## El Paso County Parks

### Agenda Item Summary Form

**Agenda Item Title:** Mayberry Sketch Plan  
**Agenda Date:** December 18, 2023  
**Agenda Item Number:** #6 - A  
**Presenter:** Greg Stachon, Landscape Architect  
**Information:** **Endorsement:** X

### Mayberry Sketch Plan

Regional Trail

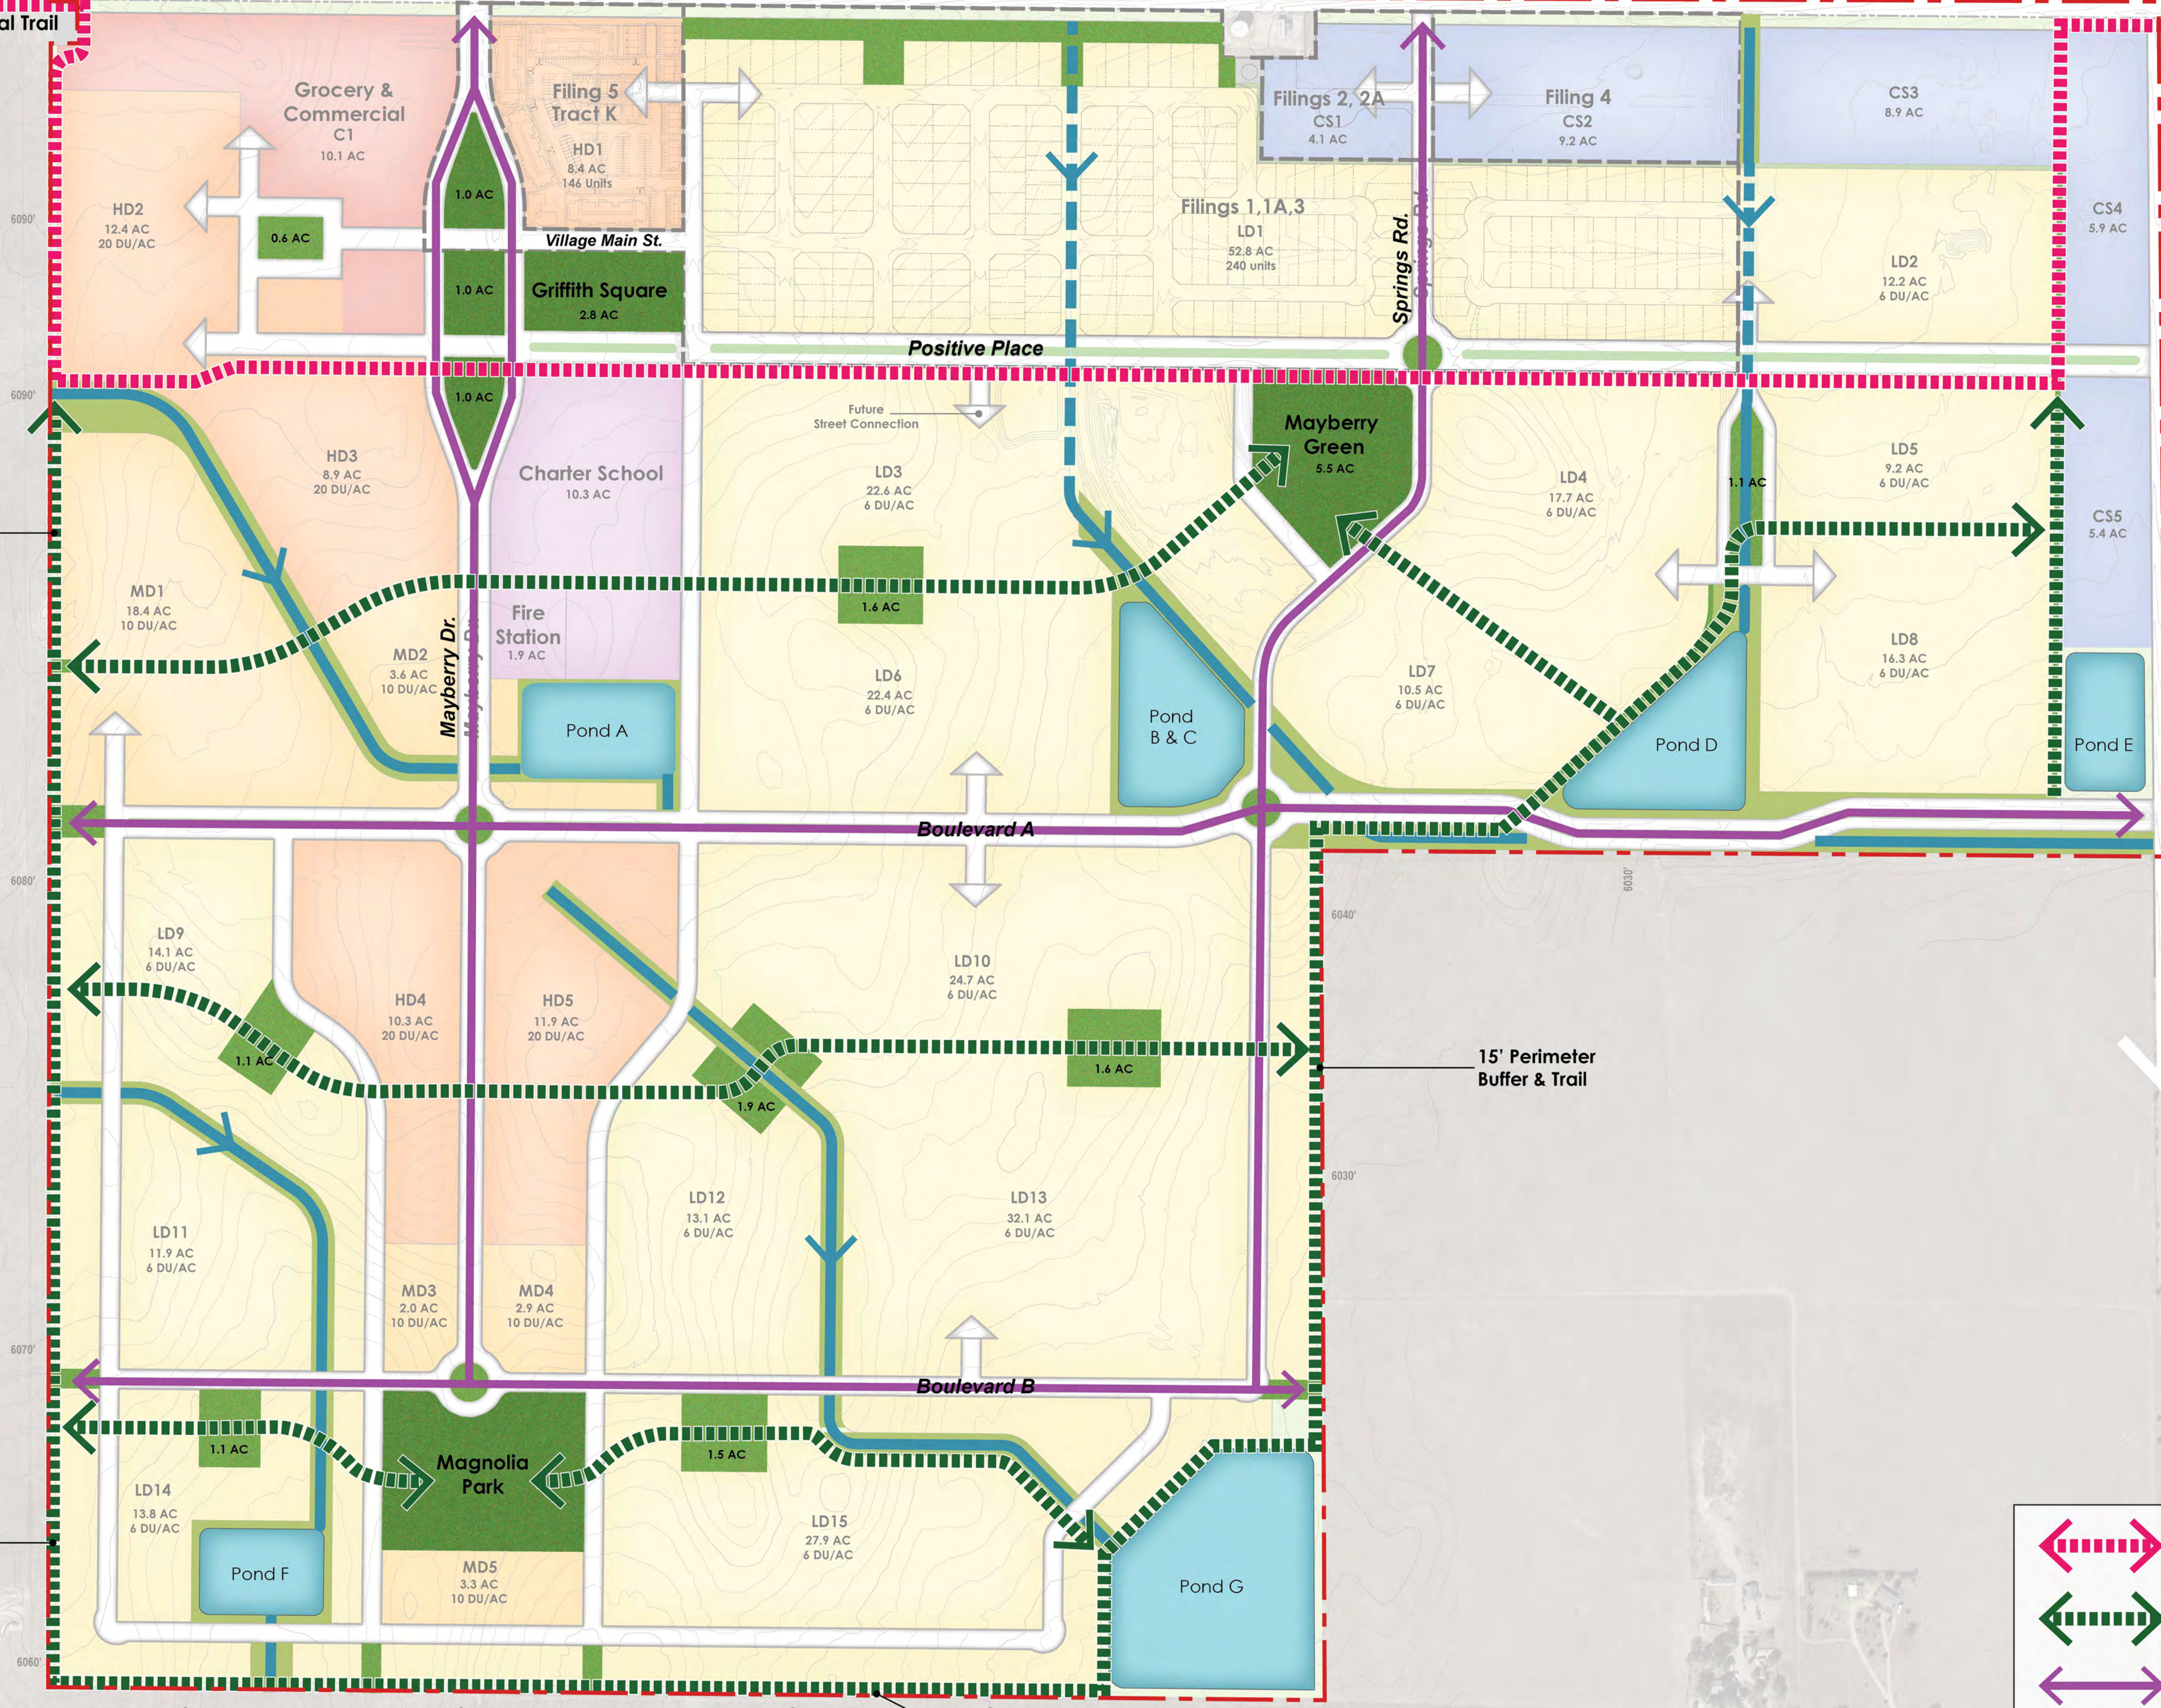
The Highway 94 Regional Trail easement has previously been recorded as a trail easement to El Paso County on Mayberry Filings 1-4. The 25' wide trail easement is on the south side of Highway 94 on the previously dedicated easements. The current sketch plan shows a 'Regional Trail' following the Highway 94 at each end of the proposed development, then going south approximately 1,100' before turning into an east-west trail. The Highway 94 Primary Regional Trail is a trail that will connect Ellicott, CO to Colorado Springs, CO and will be 10 miles long when completed. As a regional trail connecting communities, it will not have tangents and instead will have a straight alignment following the southside of Highway 94. The regional trail needs to be adjusted closer to the mater-planned trail alignment.

The Park Advisory Board recommends that the Planning Commission and the Board of County Commissioners include the following condition when considering and/or approving the Mayberry Sketch Plan: (1) designate and provide to El Paso County a 25-foot regional trail easement along the south side of Highway 94 that allows for public access, as well as construction and maintenance by El Paso County of the Highway 94 Primary Regional Trail; (2) show the regional trail easement on the forthcoming Preliminary Plan and Final Plat(s); (3) dedicate the regional trail easement to El Paso County prior to the recording of the Final Plat(s); (4) Adjust the Regional Trail shown on the sketch plan to follow Highway 94 in a straight line, offset only by the existing water tank property. (5) fees in lieu of land dedication for urban and regional park purposes will be required at time of the recording of the forthcoming Final Plat(s). (6) Add open space to meet the 10% PUD open space minimum.
